Subject: Fwd: Final version of email to WS

Dear Mr Simcock

Project Title  
**Proposed Residential Development  
Denby Lane, Grange Moor**

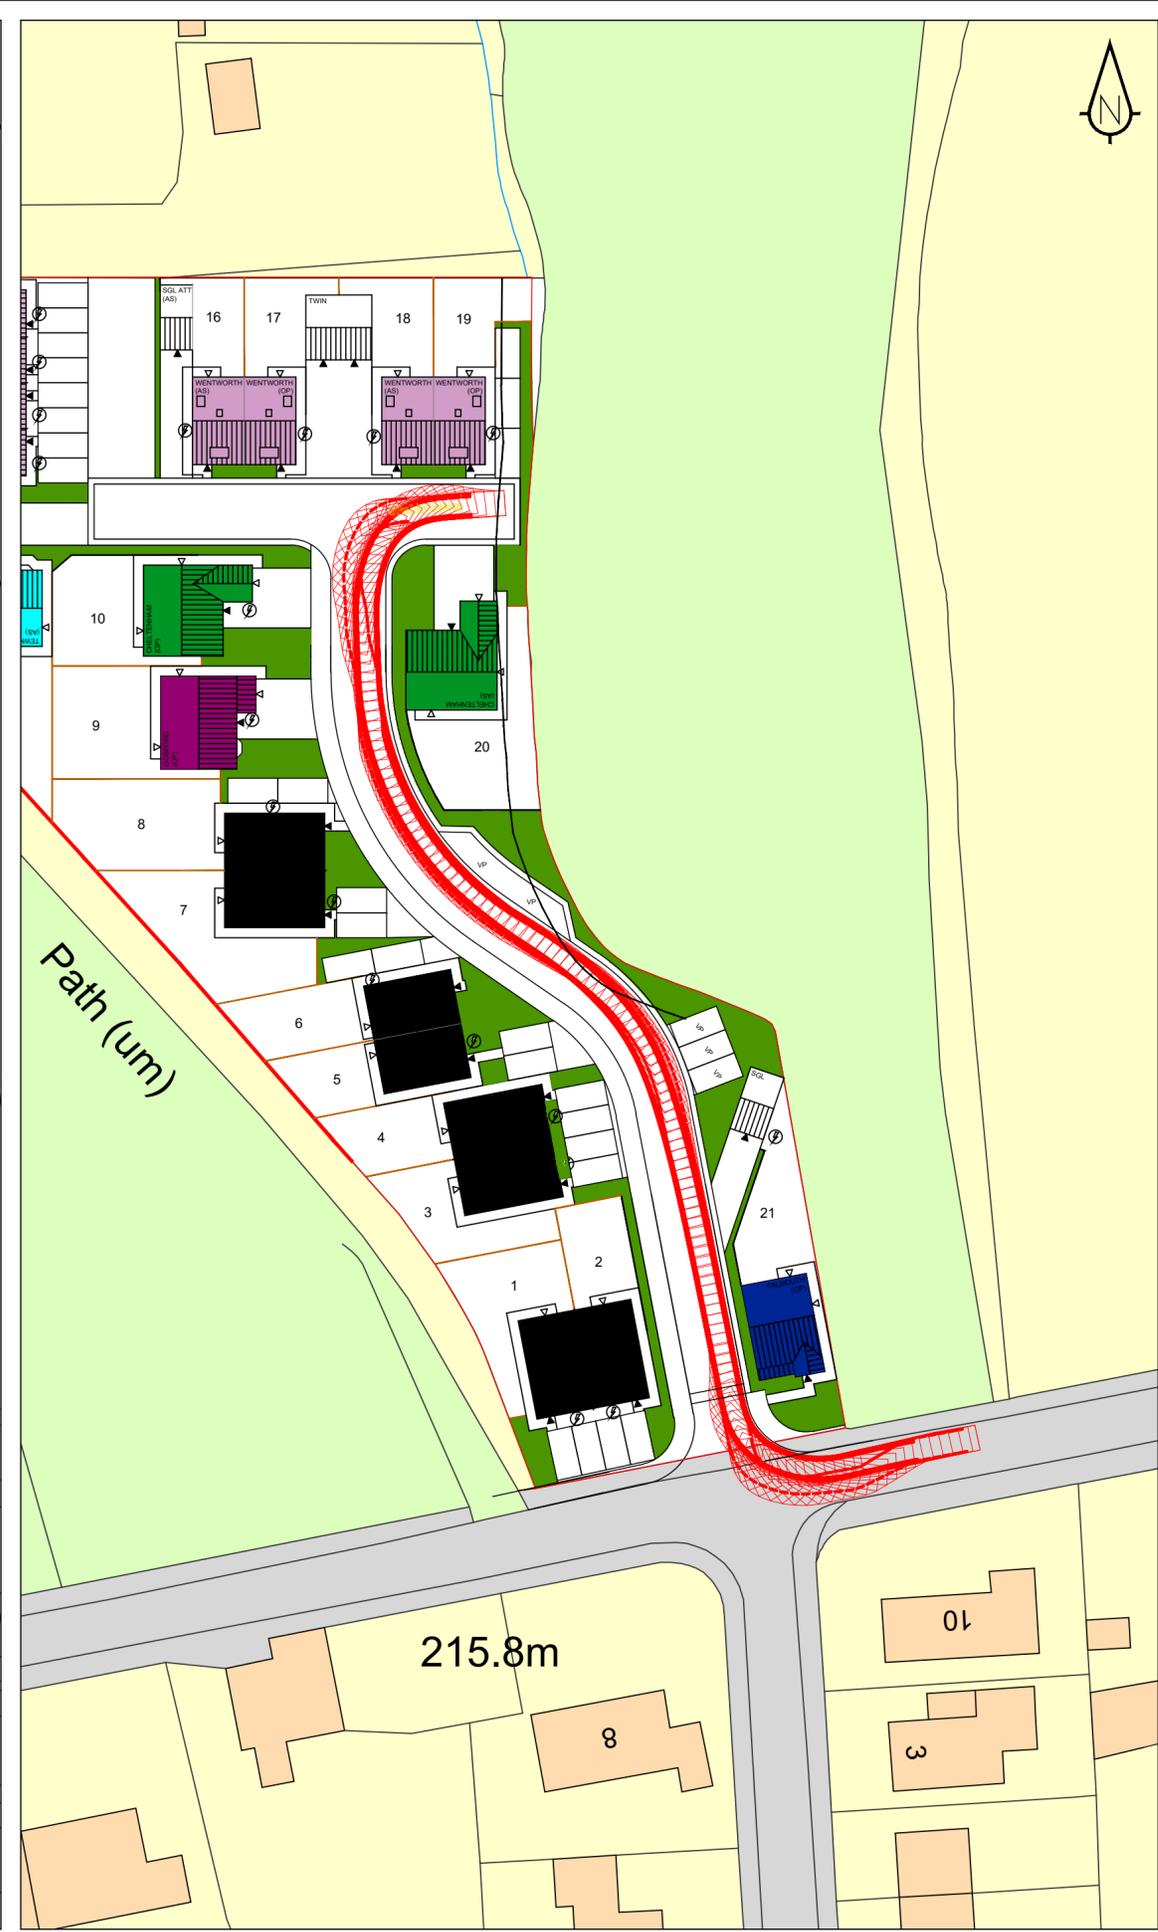
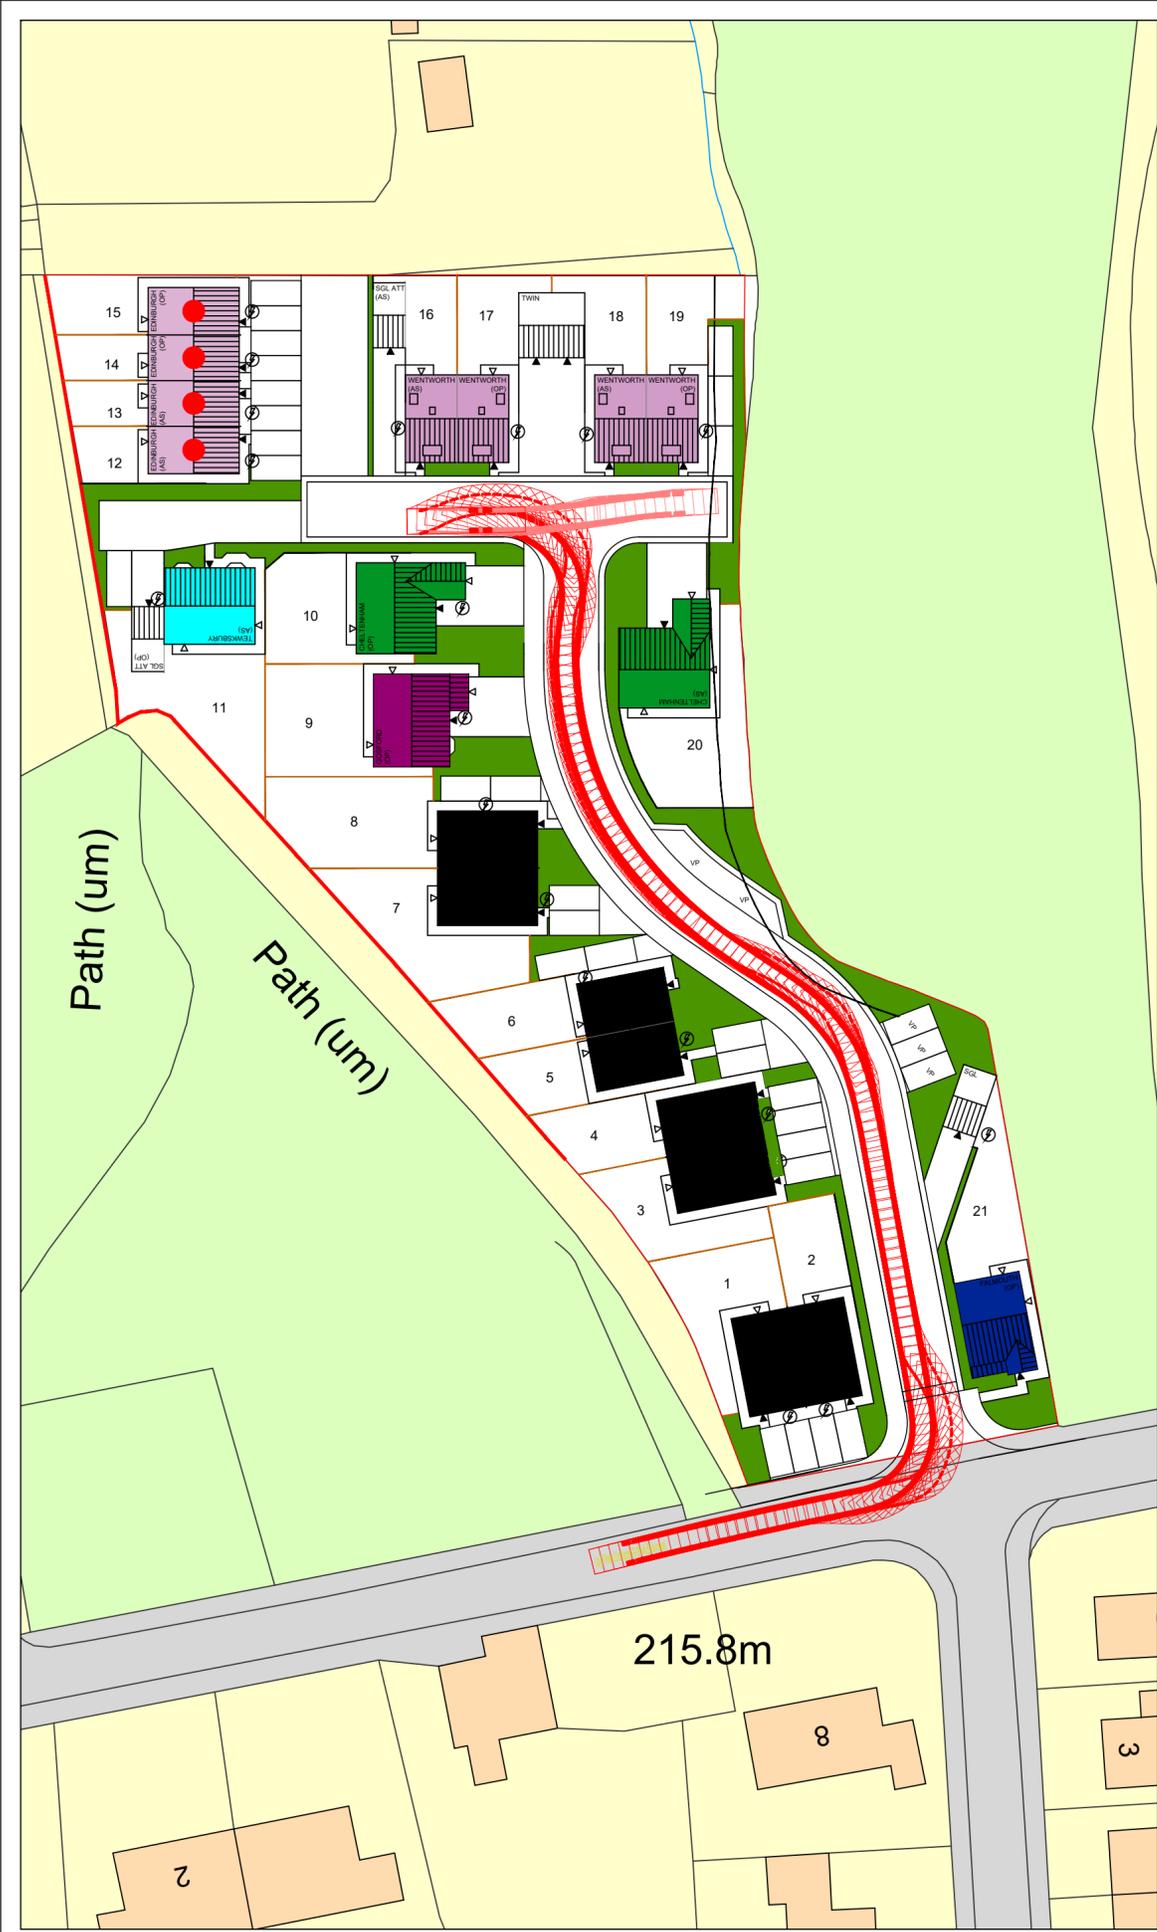
1. Although the visibility splay is now imposed on the topographical survey my comments upon the speed survey data (as set out in my previous letters) still applies. In addition, plan "003" still does not show any road widening on Denby Lane (in the direction of the Ben Booth Lane junction) that is likely to be necessary to permit large vehicles to turn both right into the proposed development from Denby Lane and left out of it to Denby Lane, see extract below.

Again, this point was raised in my last detailed letter to you. If road widening is required, which is my belief from the swept path diagrams previously submitted by Sandersons, then this may impact on the nearside kerb line of Denby Lane and hence on the delivery of the sight line looking left from the proposed junction. Notwithstanding any grant of planning permission, it is likely that the Council will examine these matters further at the stage of estate road adoption and therefore it is appropriate that they are considered now.
